A428 Black Cat to Caxton Gibbet improvements

9.53 Applicant's comments on the WSP Technical Note in relation
to the Roxton Road Link

Regulation Reference:	Rule 8(1)(k)
Planning Inspectorate Scheme Reference	TR010044
Application Document Reference	TR010044/EXAM/9.53
Author	A428 Black Cat to Caxton Gibbet improvements Project Team, National Highways

- 1.1.1 The Applicant has prepared this report in response to a Deadline 3 submission from Duncan and Maxine Buchanan titled 'Alternative highway and drainage options for Roxton Road link (north)' (the WSP Technical Note) with document reference: 1368-WSP-00-XX-RP-CV-0002 dated 09/06/2021' **[REP3-046]**.

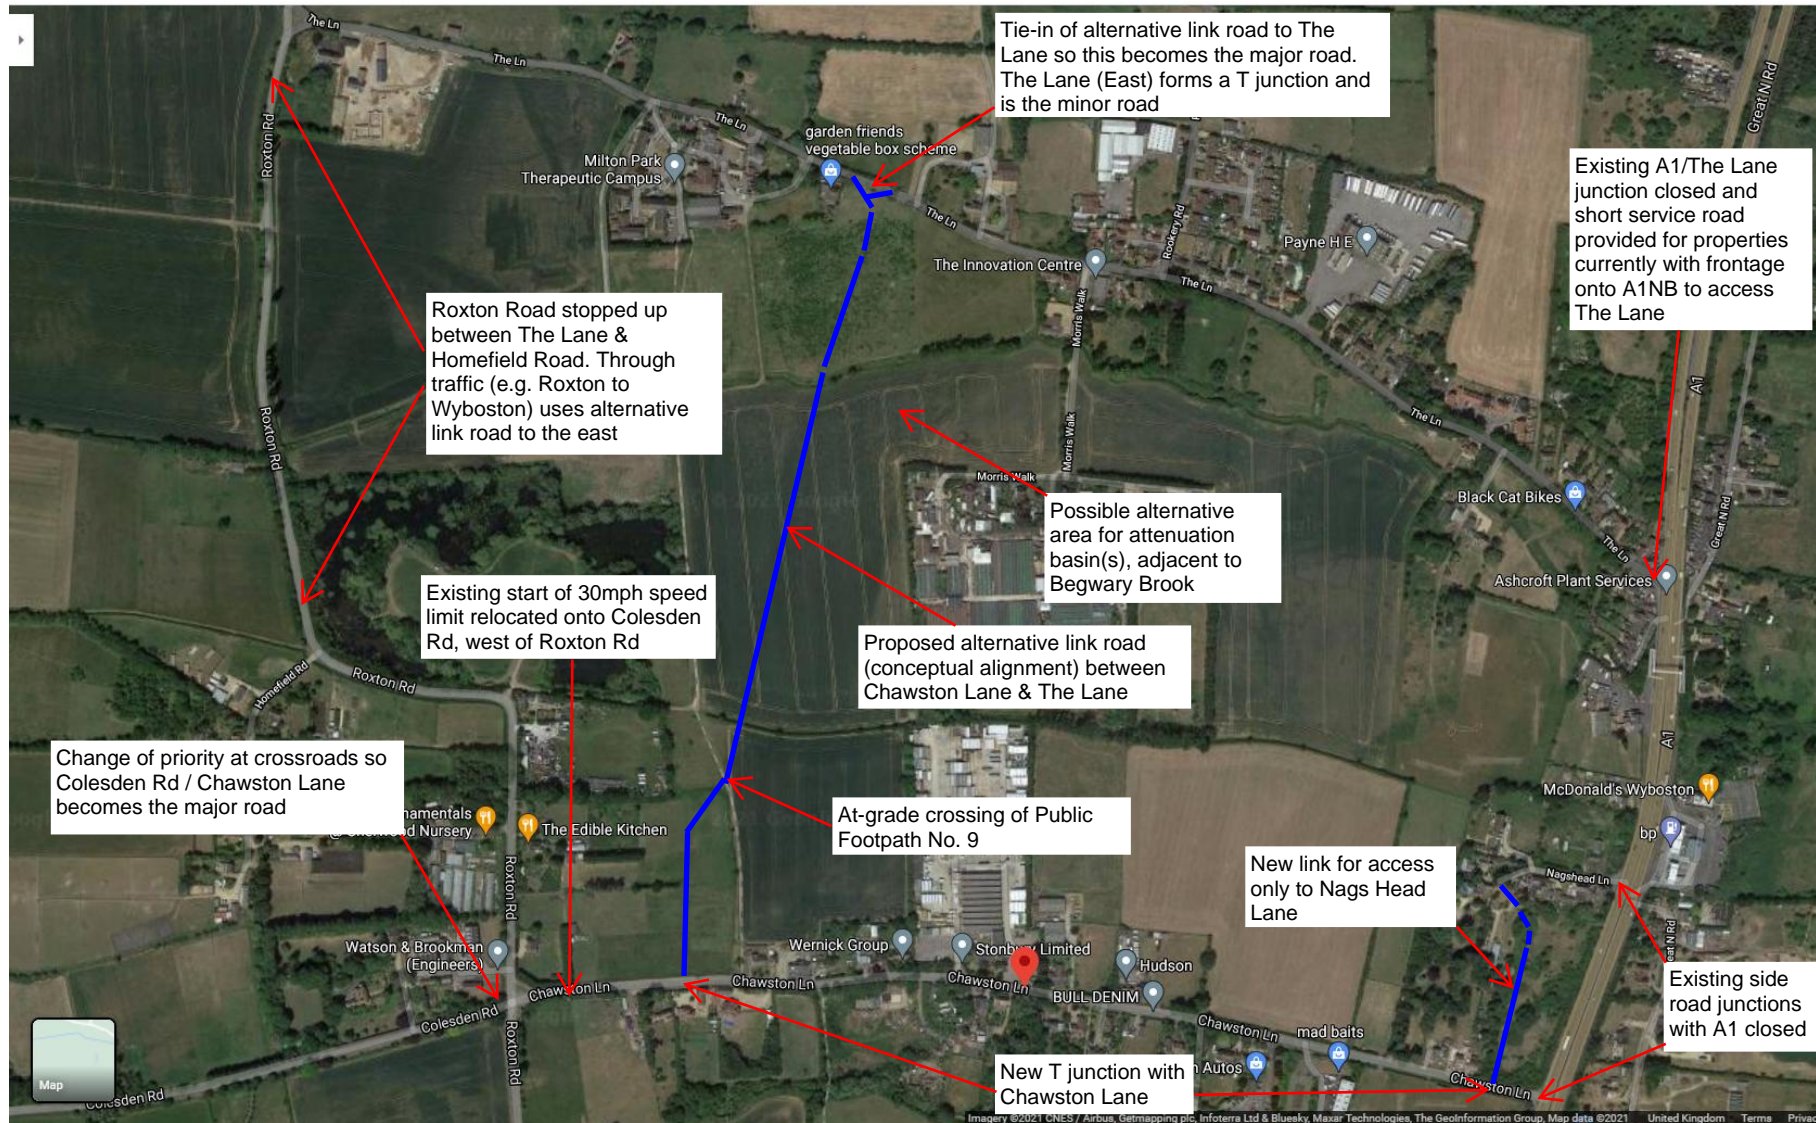
- 1.1.5 Page 1 (i) of the WSP Technical Note acknowledges that the WSP alternative design put forward in the 2019 Technical Note requires more land than the Applicant's Scheme design. It notes that there may be opportunity to refine the WSP drainage design so that it uses less land. A potential way to achieve this is described on page 3 of the WSP Technical Note, but it is not a reduction in land required, rather it proposes to create another drainage pond elsewhere to reduce the land required within Dove Farm, so it is a reallocation rather than a reduction.

- 1.1.6 Page 1 (ii) of the WSP Technical Note states that the WSP alternative design was based on PDF versions of the National Highways Scheme design presented at Statutory Consultation. Whilst that may be the case, the comparisons between the two designs were made using PDF versions of both. The comparison measurements, whilst they may have been different if made using CAD versions of the drawings, are relative and measurements between the two were possible by calibrating them against the scale bars included on the drawings. It is the Applicant's view that the WSP alternative design does use more land than the Applicant's original.
